Subject: AB/1/21/L

Walker House 14 Tarrant Street Arundel BN18 9DG

Listed building consent for the renewal of existing slate roof replacement of 2 No. window frames on front elevation & painting west elevation & rear garden north & east elevations.

North and East Elevations

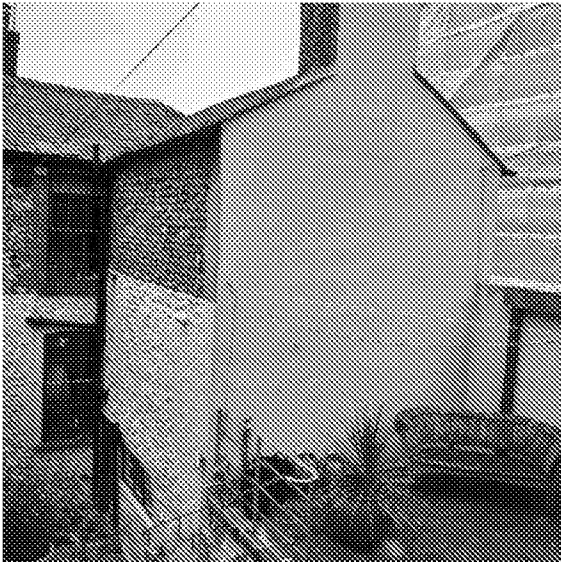
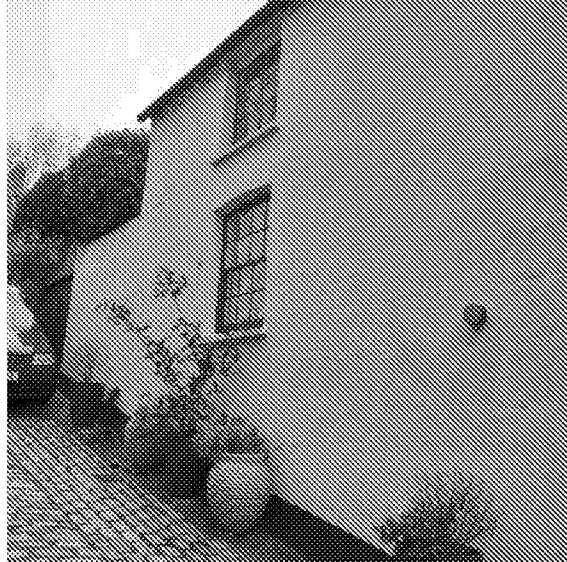
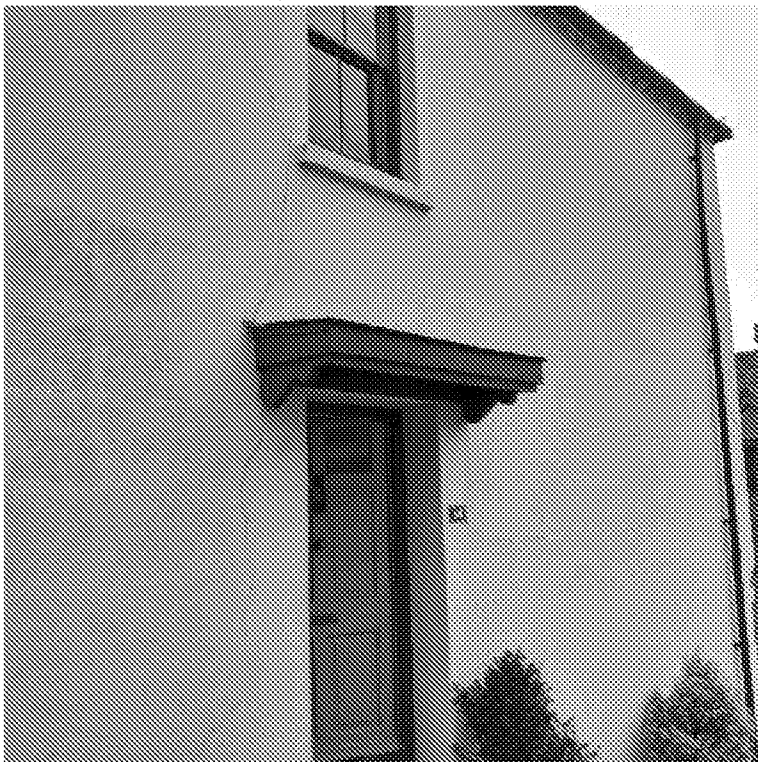
It would appear that the proposed redecoration is to only cover over those areas already painted, leaving the existing exposed flint areas in their current condition. The proposed paint colour appears to be acceptable.

Fig. 1 . Cracking of bay at junctions – Photo taken March 2019.

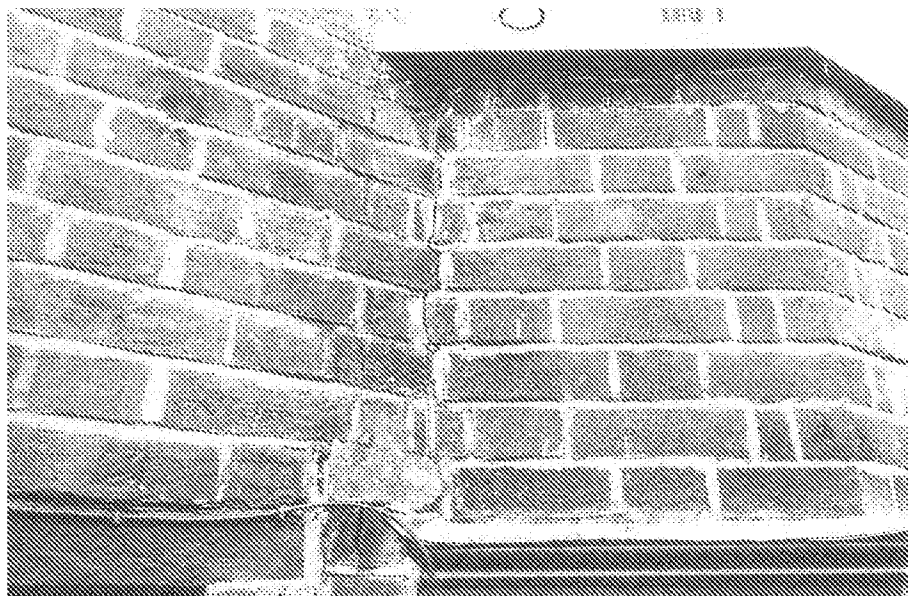
It is noted that replacing the existing window frames will be undertaken on a like for like basis and that the existing sashes and glazing will be retained. Works to stabilise the bay window will include Helibar reinforcement, replacing elements of the brickwork and repointing in lime mortar. Whilst these elements are acceptable, it would be useful to understand what the replacement bricks will look like, along with the method for removing the existing repointing.

- Details of the slate
- Details of the brick
- Method for removing the existing lime mortar

West roof slope—slipped slates lying in gutter ...

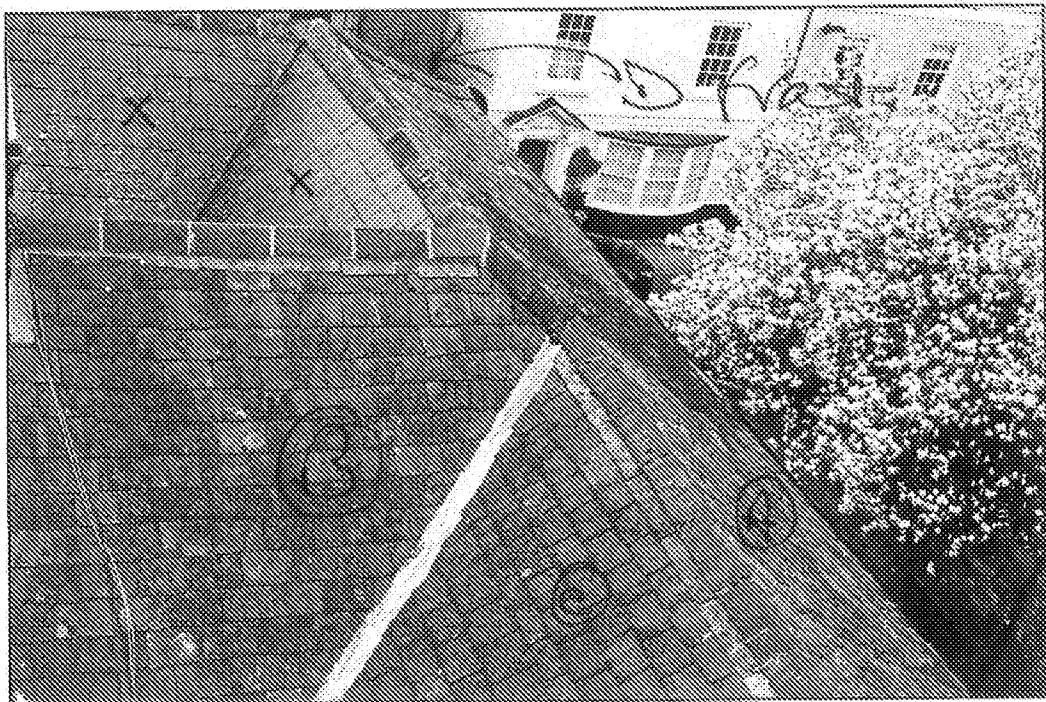
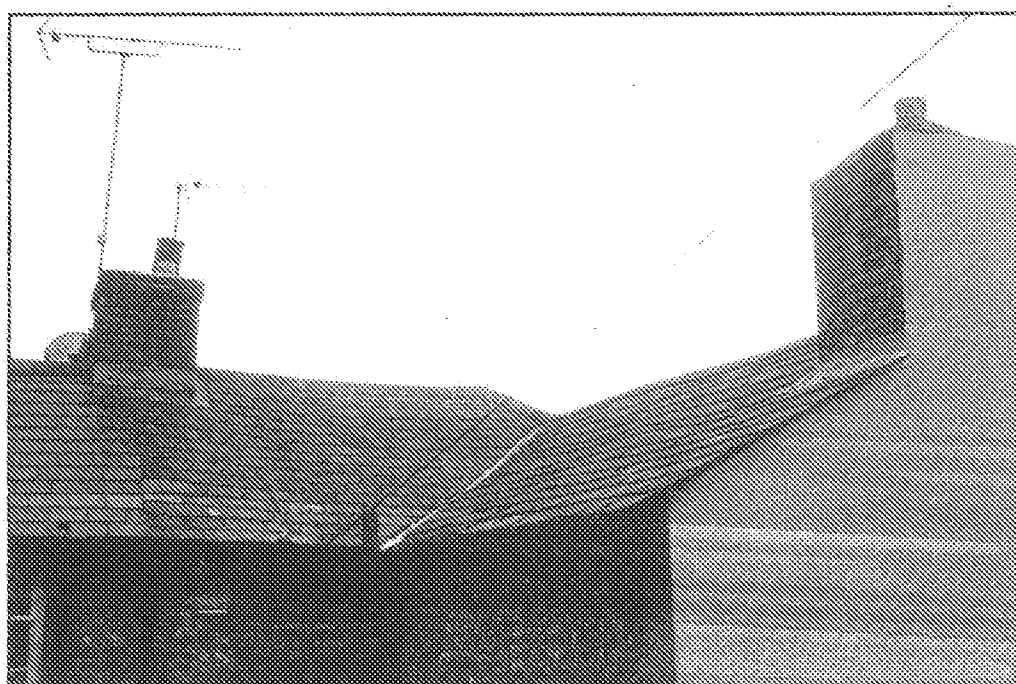
It would appear that the intention is to only renew the slate on certain parts of the roof, and not all of it as indicated by the application description. Whilst this element is acceptable, it would help to have further details of the slate in order to ensure that it is appropriate for the listed building and conservation area. Such details can be provided for by way of condition, if you are minded to approve the application.
